Our ref: AN/2023/133932/06-L01
Your ref: EN010127
EA unique ref: 20036496
Date: 24 October 2023

**Planning Act 2008 - application for a Development Consent Order for Mallard Pass Solar Farm: Deadline 7 submissions published - Rule 17 Letter and ExA's questions on the draft Development Consent Order
Land either side and in the vicinity of the east coast main line, near the village of Essendine (Rutland And South Kesteven)**

Environment Agency's response to the Rule 17 letter request for further information dated 18 October 23

Figure 2 - 0.5% AEP Depths

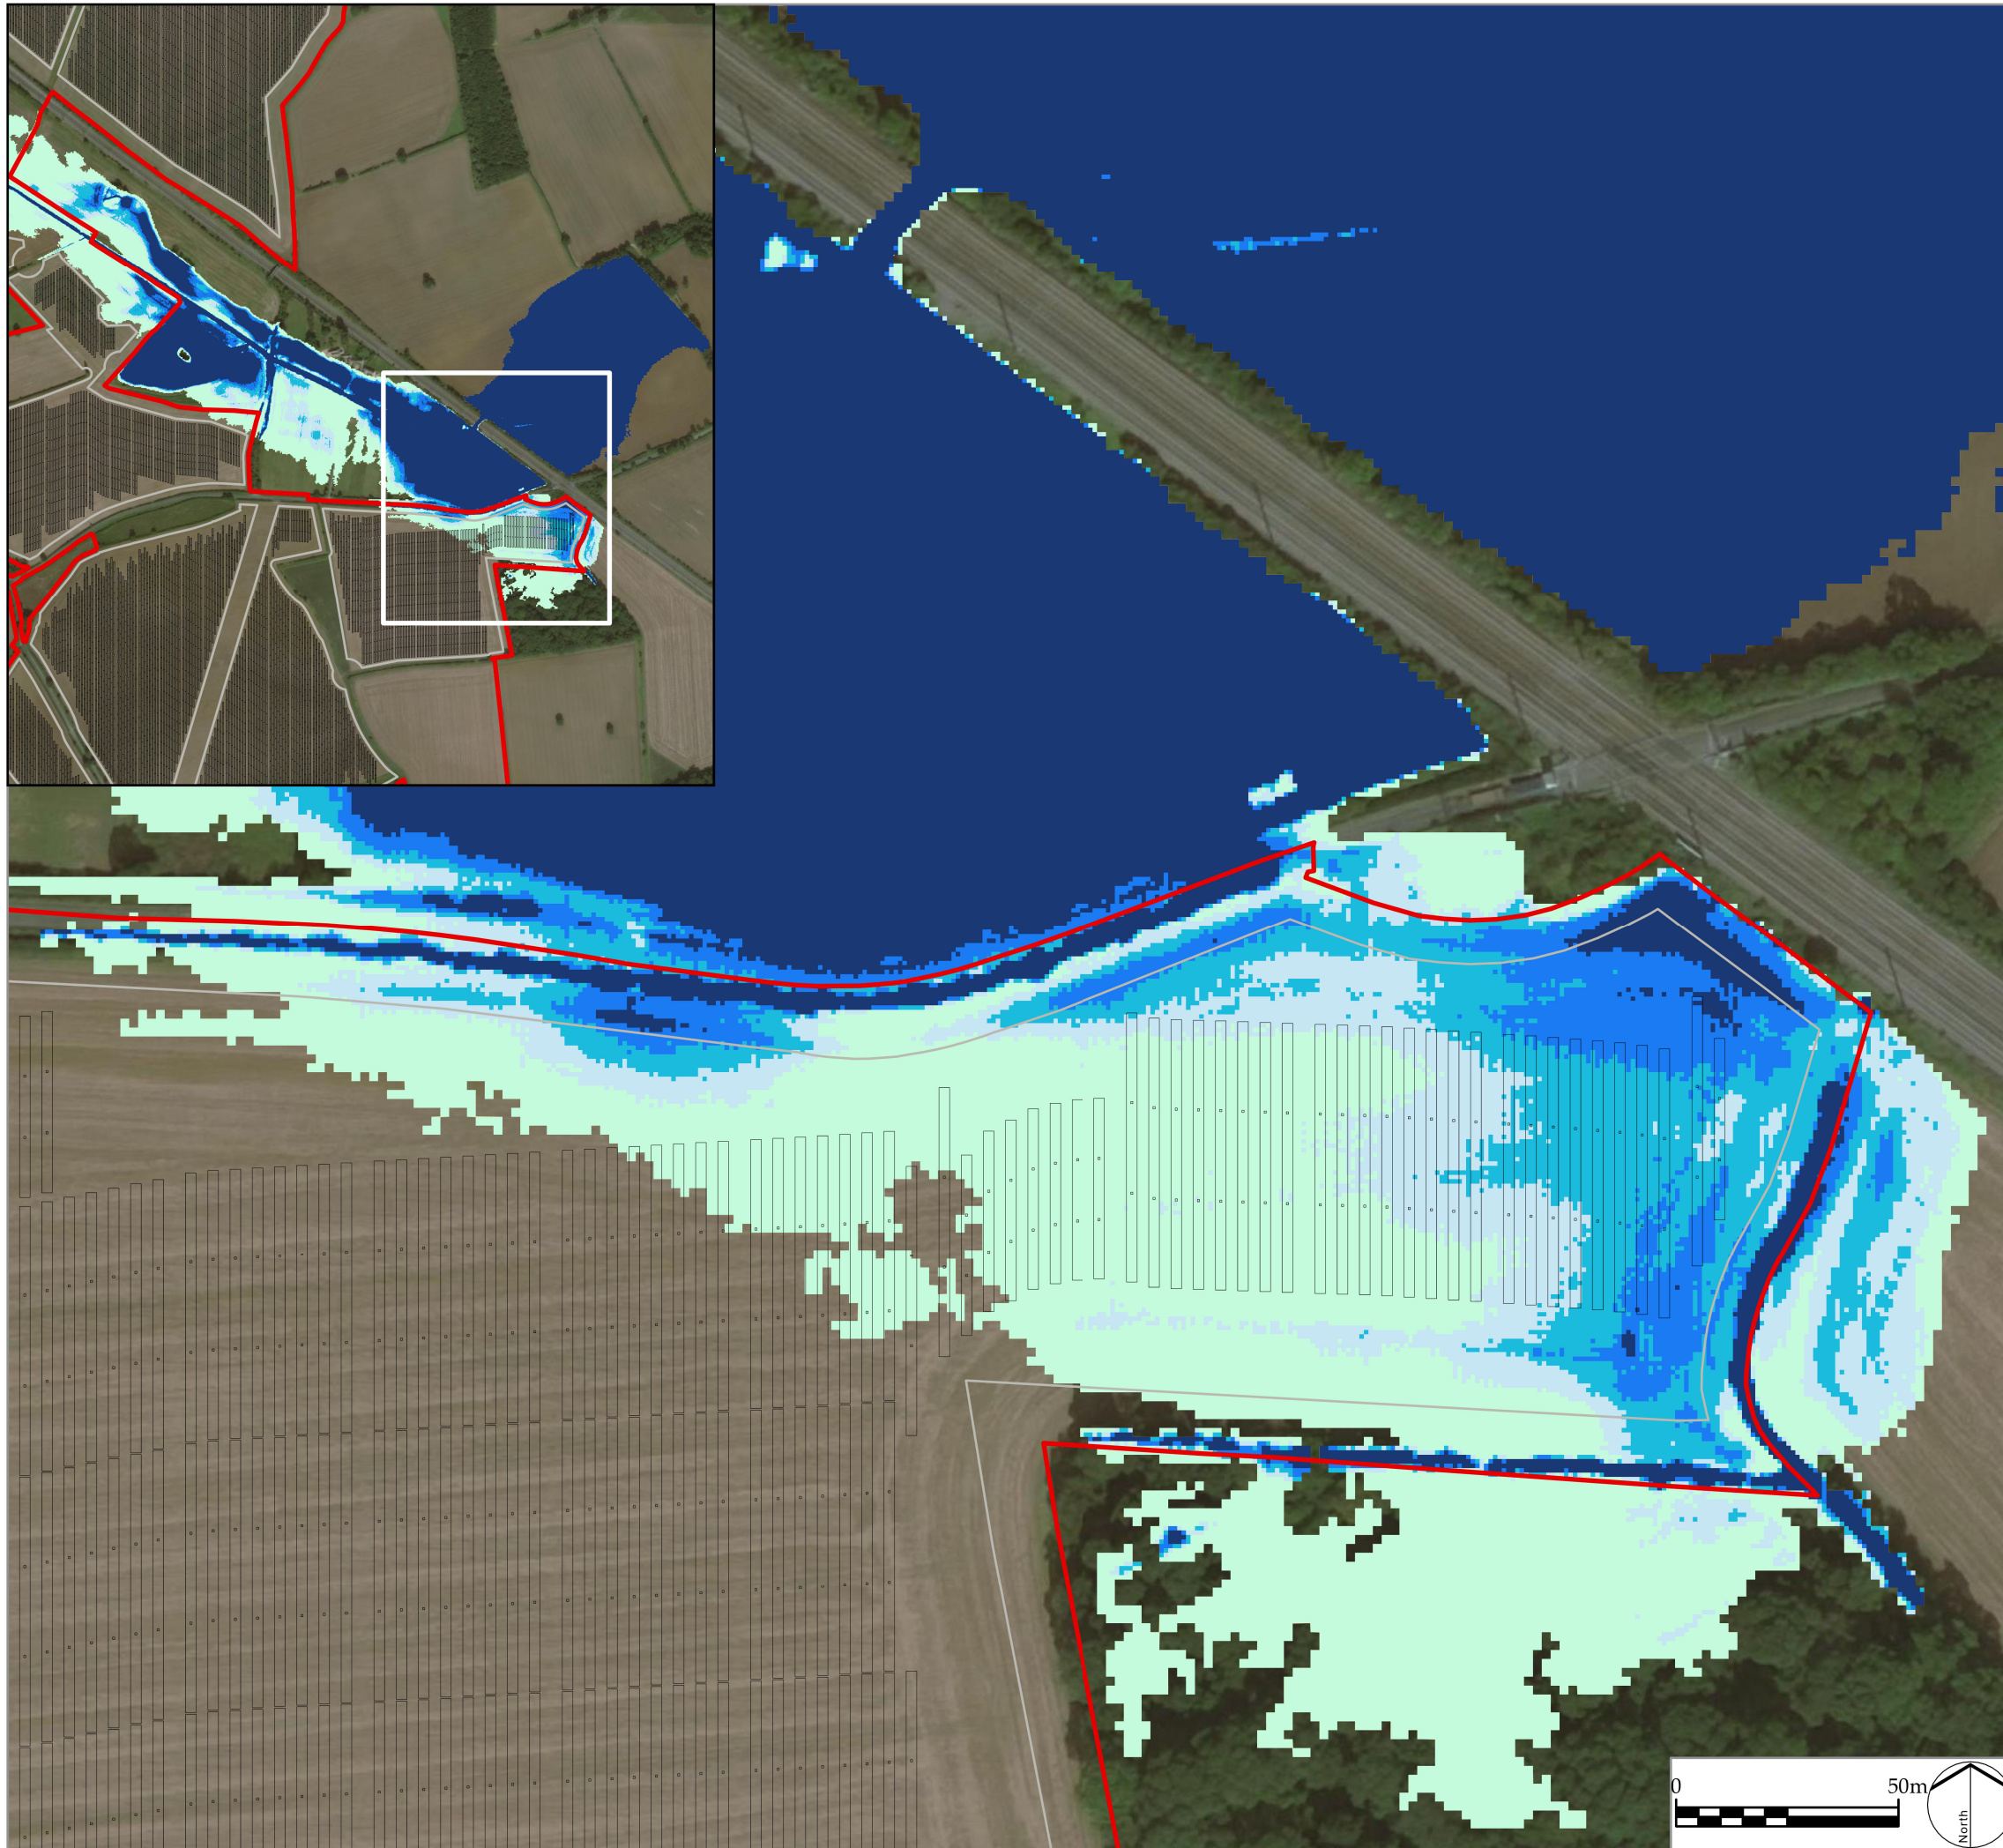
The updated model has not been provided for review by the Environment Agency; however a summary of the results has been provided which is adequate and appropriate for the proposed development. The modelled extents (as shown in drawing

No. 2, Appendix X, Rev 0, dated 04 October 23) align with the Environment Agency's flood extent data. This shows that an area may get flooded with depths of up to 0.1m and 0.2m: this would fall within the model tolerances and is not considered significant. There is a small area where depths fall between 0.3m and 0.4m: as the leading edge of the PV array tables will be 0.8m above ground they will not be affected. The supporting structures are designed to be flood resistant and are not of a scale to cause any impact on third parties through displacement of water, should flooding occur.

We agree that the applicant's conclusions are satisfactory and remain satisfied that the 0.5% AEP event is a good proxy for the climate change allowance for the 2080s epoch. We do not require any additional mitigation measures.
